Re: TODOS SANTOS RV STORAGE PARK

Traffic Circulation Layout

Engineer's Stamp Dated 4-28-24 (G10D036)

Based upon the information provided in your submittal received 5/1/24, the above referenced plan cannot be approved for Building Permit until the following comments are addressed

DRAWING:	DRAWN BY:	DATE:	SHEET #
202408-SP.DWG	SH-B	04-29-2024	1

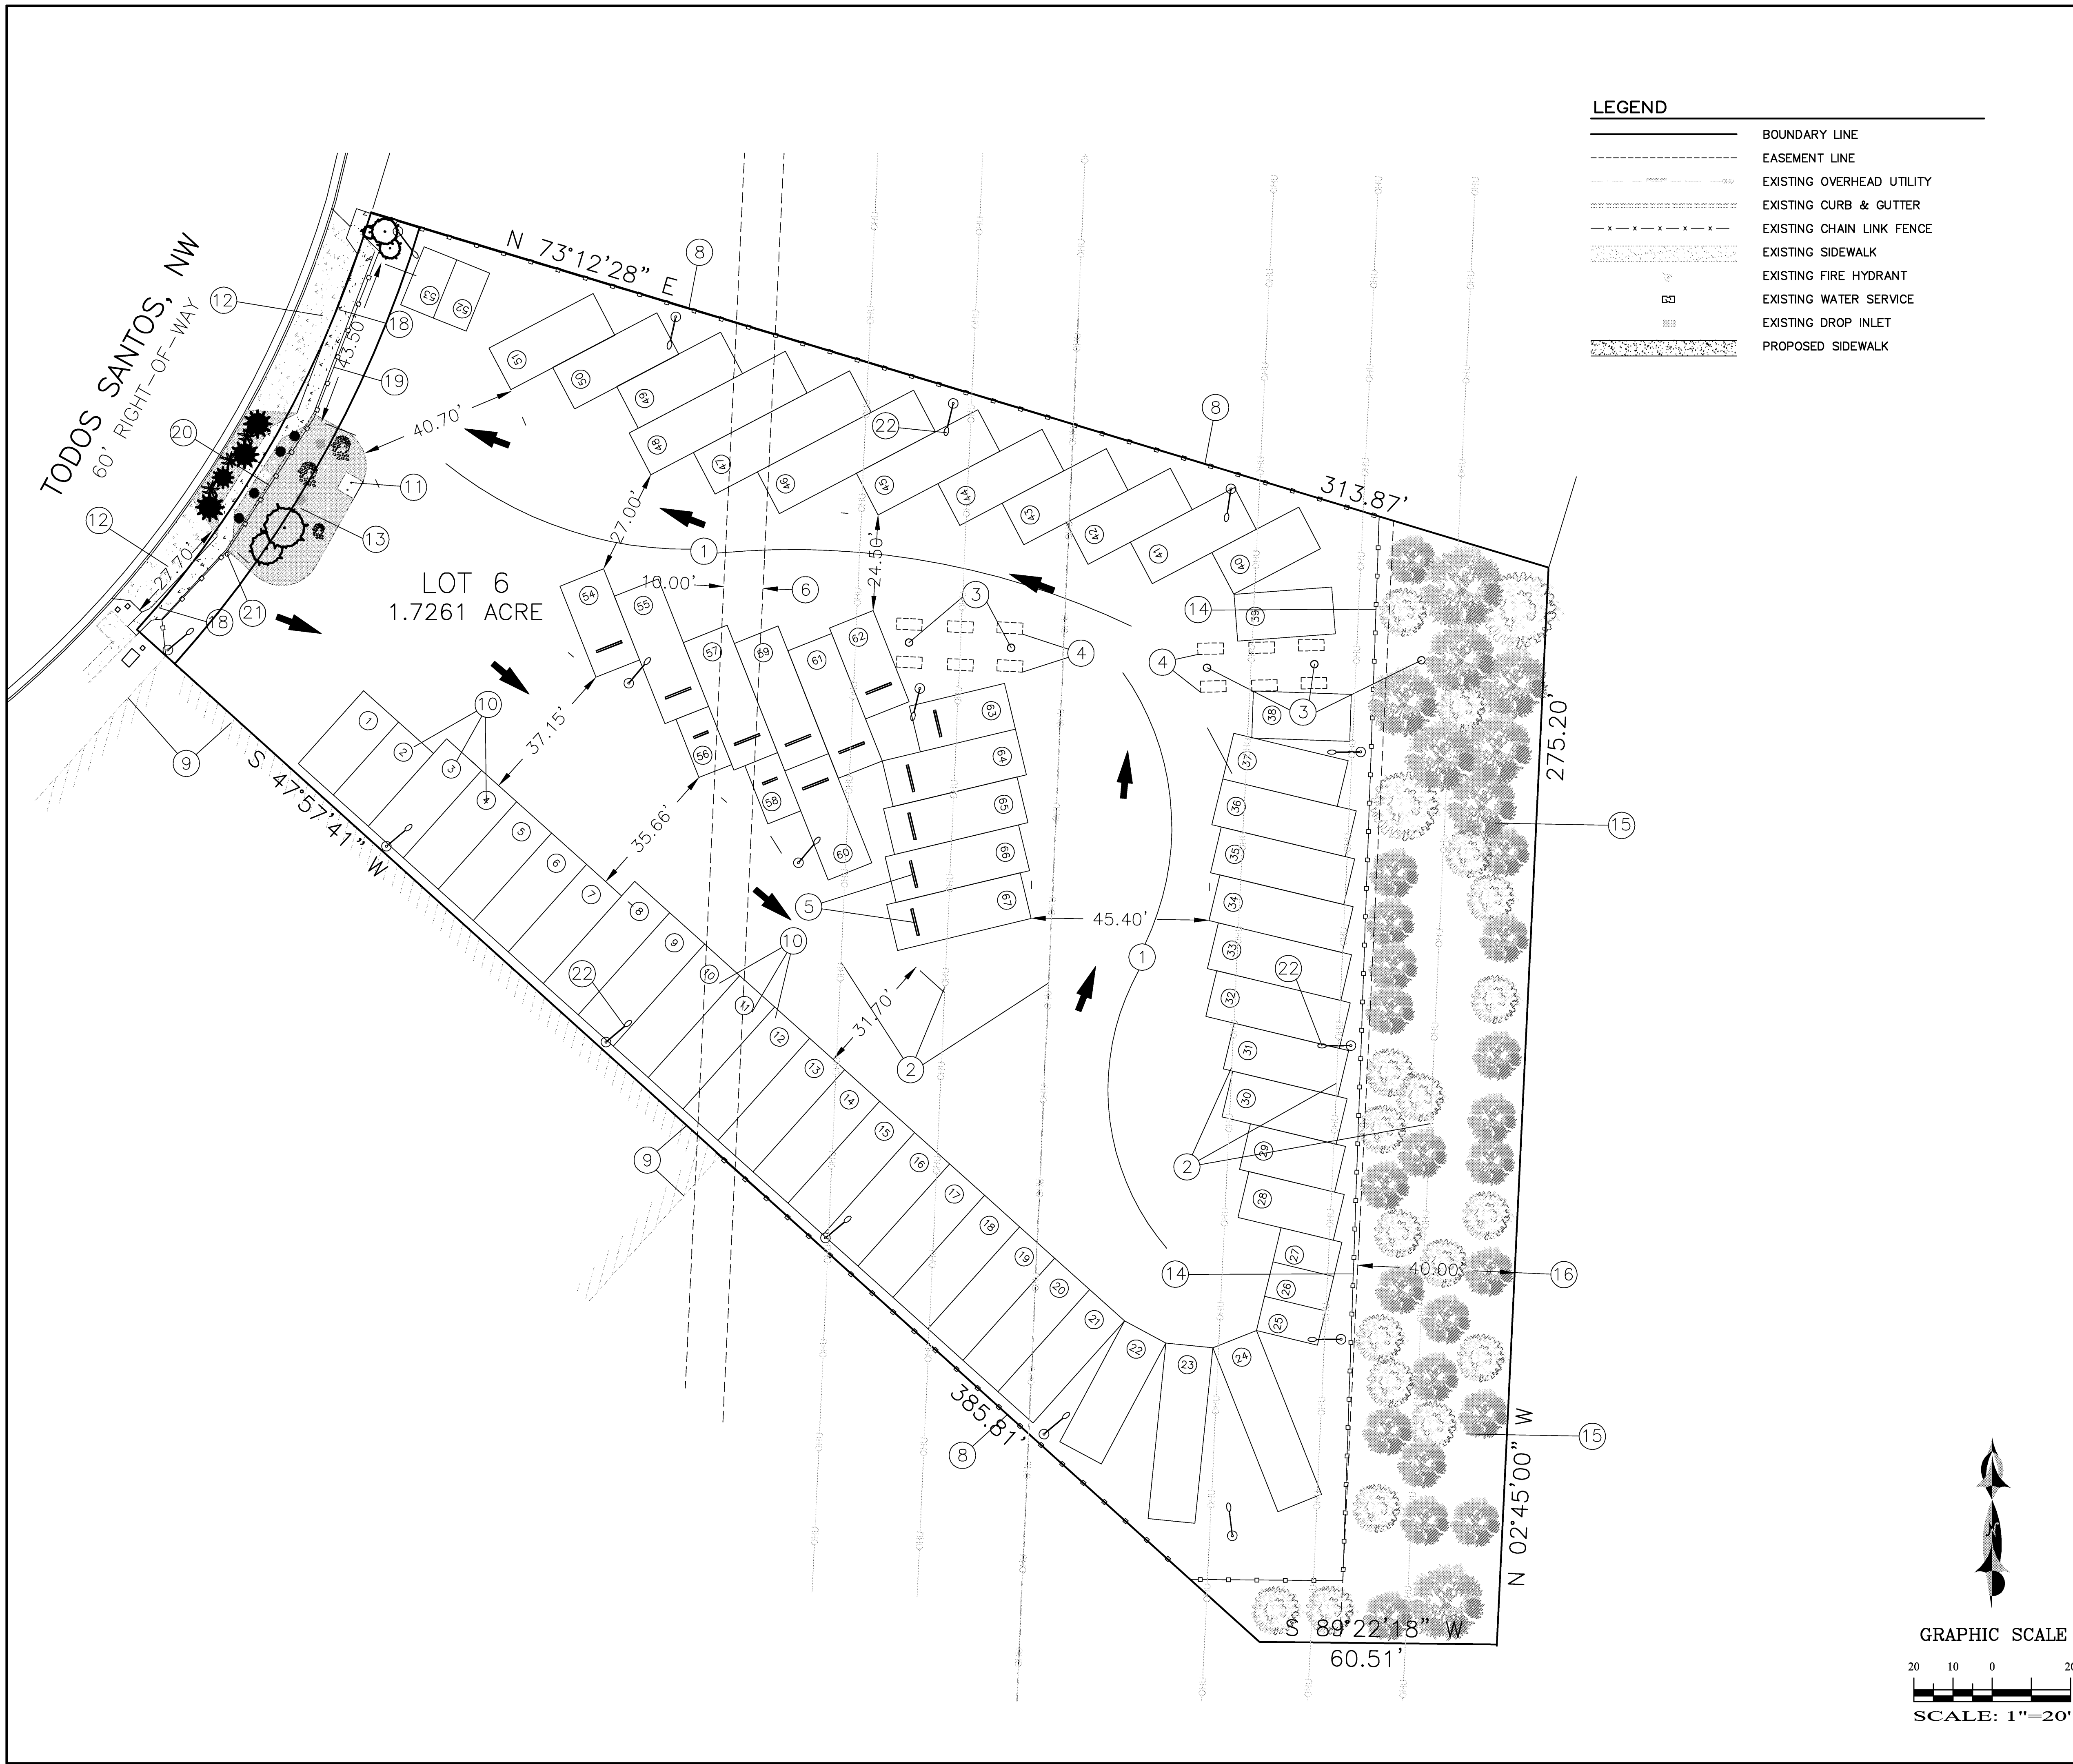
1. Show the clear sight triangle and add the following note to the plan: "Landscaping and signage will not interfere with clear sight requirements. Therefore, signs, walls, trees, and shrubbery between 3 and 8 feet tall (as measured from the gutter pan) will not be acceptable in the clear sight triangle.
2. Show all private infrastructure outside of public right-of-way and all public infrastructure within public right-of-way. Any private infrastructure that is allowed by the City of Albuquerque to be kept within right-of-way shall require a revocable permit.
3. Provide documents to show that the fence was built per city requirements. see the attached document for city DRC memo.
4. Provide a plat for the lot to verify the front side boundary. It looks like that the fence need to be moved several feet backward.
5. What is this dark line represent (yellow high lighted)

6. Remove the steel tube at the north end of the fence

7. Why does the sidewalk "jog" between the entrances?
